From: Anastasiya Seddon
Sent: 15 March 2024 18:34
To: Calum Rowley
Cc: Planning
Subject: Fw: Planning Consultation for 23/03925/REG3 Goole Market Hall Estcourt Terrace
Goole East Riding Of Yorkshire DN14 5AB

Anastasiya Seddon

Highway Development Management Officer

Figure 5.1 Service Area (Showing Cycle Storage)

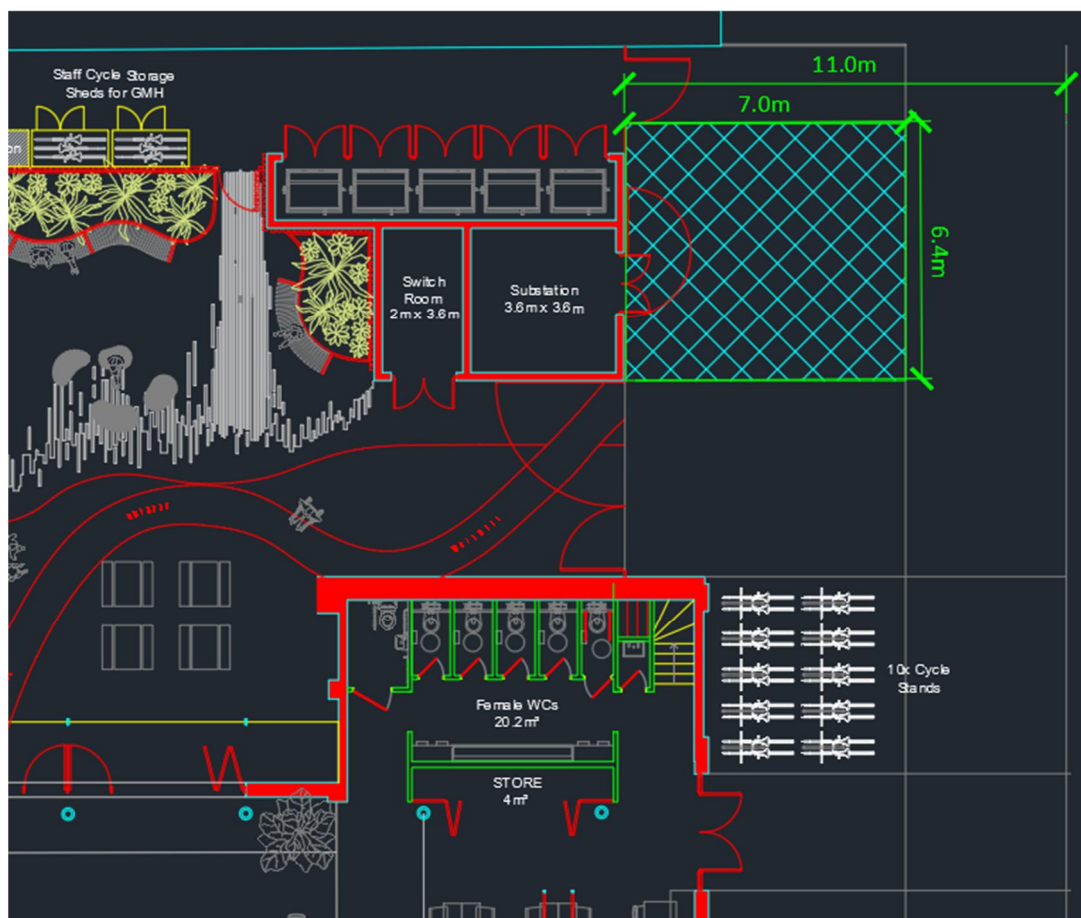
The service area is not shown within the red outline. I would consider the hatched area outside the gates at the eastern side of the site to be used for servicing, as was suggested by the agent, if it is controlled to prevent parking and no clash of use with pedestrians. However, as I understand it cannot be formally considered if not included within the red outline.

I raised my concern in regards to the area outside the gate at the eastern side of the site being currently used by pedestrians, cyclists and vehicles parking. The low kerbing between the footpath/cyclepath and the carriageway means vehicles have unrestricted access and drive/park within areas meant for pedestrians. The mitigating measures to prevent this from happening should be provided by the applicant. As they propose new pedestrian access (alongside vehicular) and change use of the hardstanding yard/service area to public recreational garden area the priority shifts to pedestrians. Therefore, mitigating measures should make provisions to maintain safe pedestrian access at all times. As proposed, all I can see is conflict of use between vehicles and pedestrians.
